TM312-03F01 Ardex Warehouse Kemps Creek RfS Comments (r1)

## **Proposed Ardex Warehouse & Manufacturing Facility, 657-769 Mamre Road, Kemps Creek - Response to submissions - Noise and vibration**

Renzo Tonin & Associates (RT&A) has been engaged by The Trust Company (Australia) Limited on behalf of Altis Frasers JV Pty Ltd to undertake an operational and construction noise and vibration impact assessment (NVIA) to accompany the State Significant Development Application (SSDA) 25725029 for the proposed Ardex Warehouse and Manufacturing Facility at the proposed Lot 12, 657-769 Mamre Road, Kemps Creek (the Proposal).

B.1 Locality map, sensitive receiver type identification, and operational assessment representative receivers locations

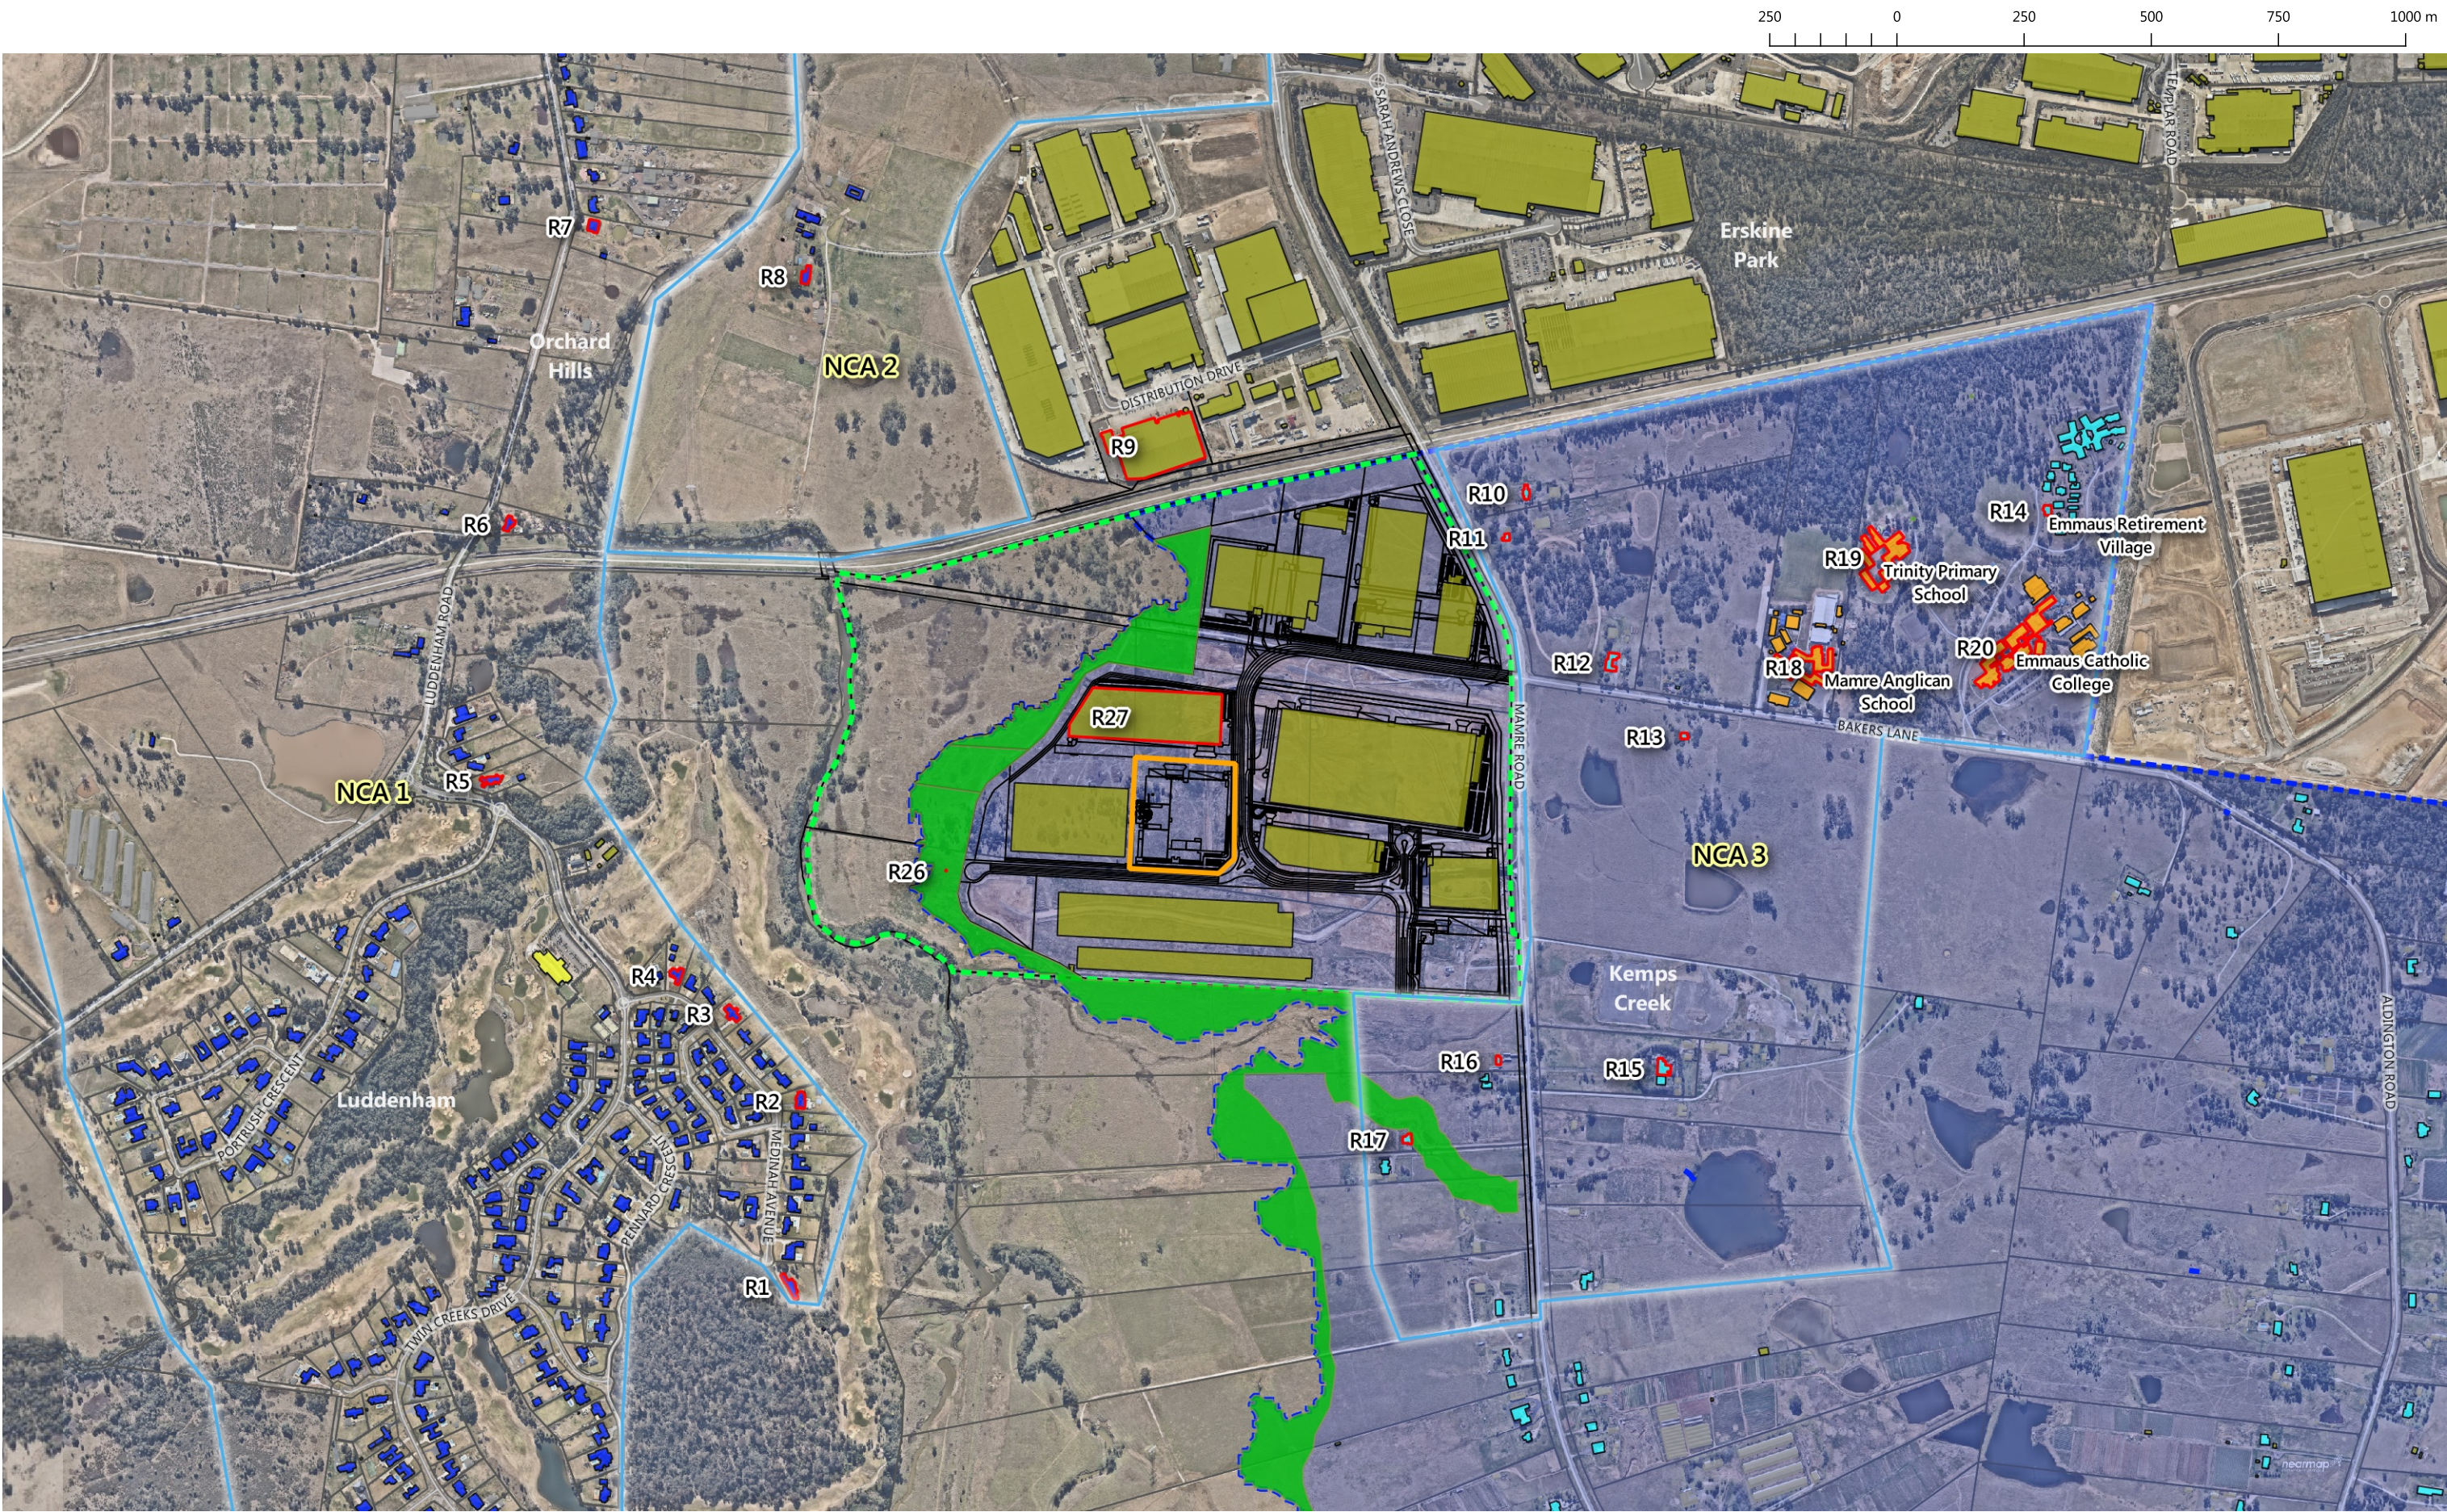
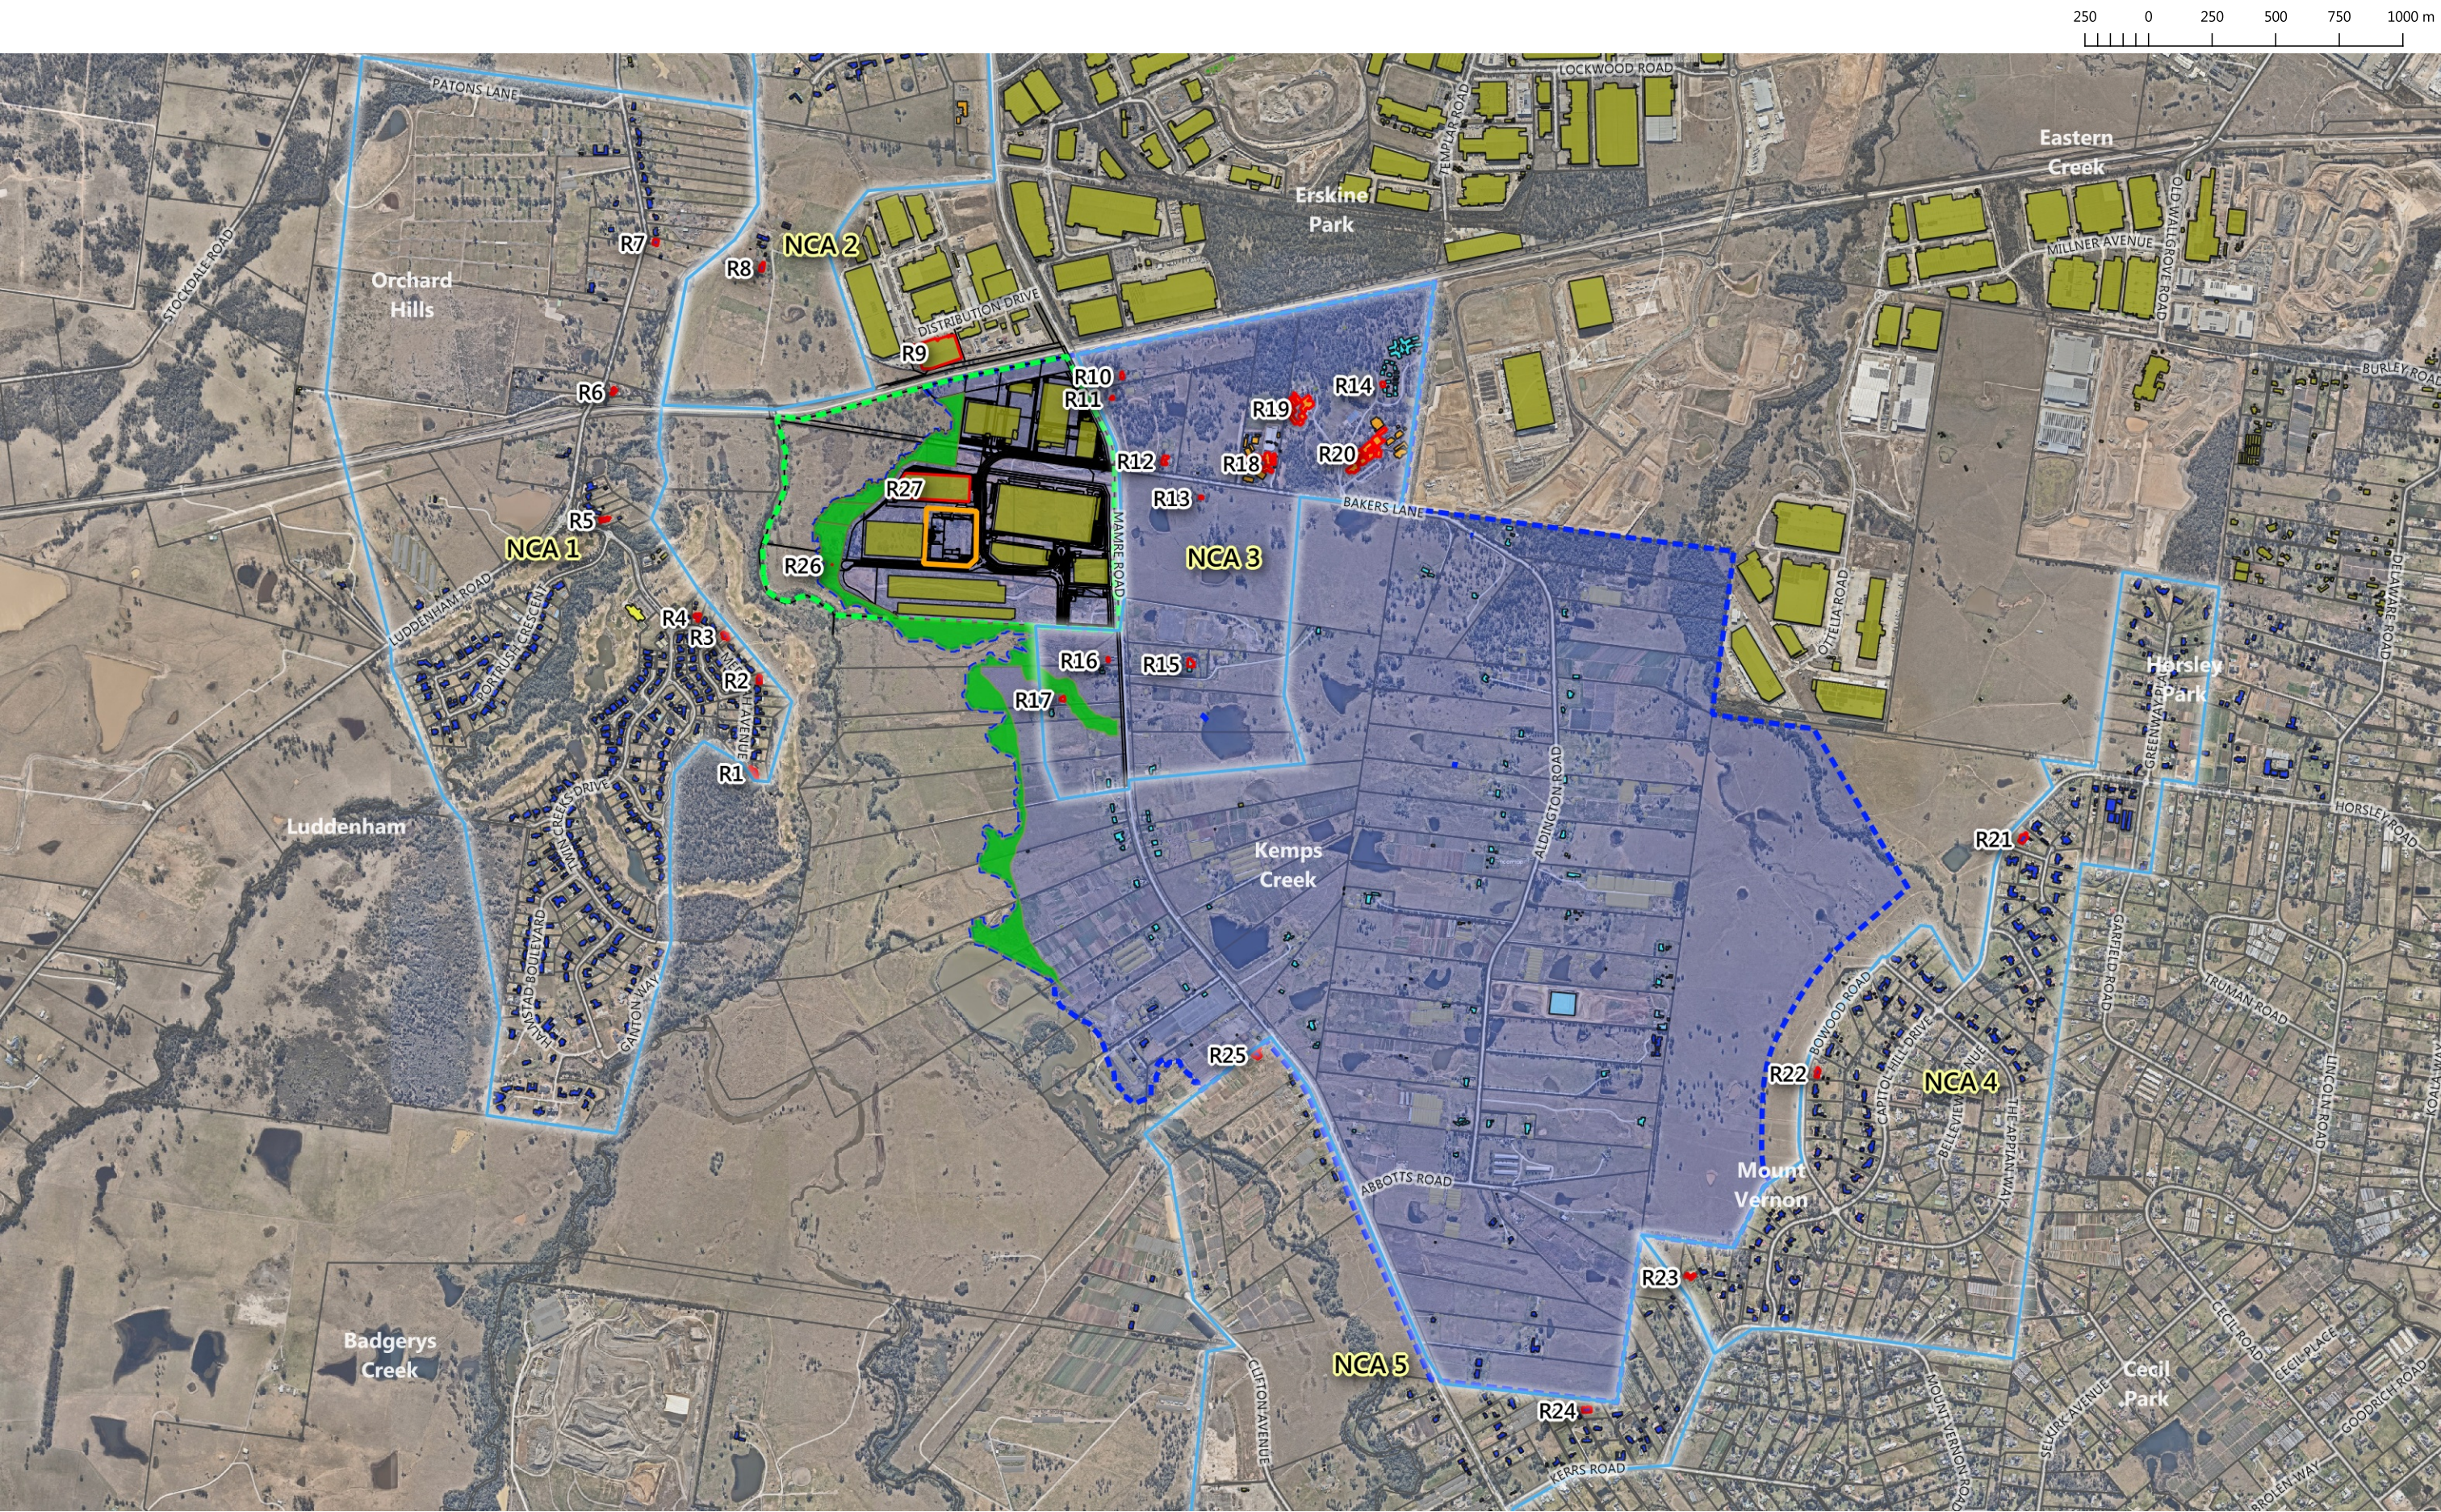
Item	Comments on NVIA	RT&A responses
18	The Department notes that Appendix B1 of the NVIA detailing the locality map, sensitive receiver type identification and operational assessment representative receiver locations is not provided. The Department also notes that Appendix E (Sections E.1 and E.2) detailing the predicted operational noise contours is not provided. The Applicant is required to update the NVIA to include Appendices B1 and E.	The updated SSDA NVIA includes these figures in: <b>Appendix B.1</b> - Locality map, sensitive receiver type identification and operational assessment representative receiver locations <b>Appendix E (Sections E.1 and E.2)</b> - Operational noise contours
19	The Department notes the NVIA considers impacts associated with the construction and operational phases of the development and the cumulative impacts. As discussed under the general comments above, the NVIA does not consider the proposed wastewater treatment plant in sufficient detail. The Department requires the Applicant to update the NVIA to include the proposed operational details of the wastewater treatment plan.	Wastewater treatment plant has been added into the updated modelling and predictions. Refer to response Item 2.
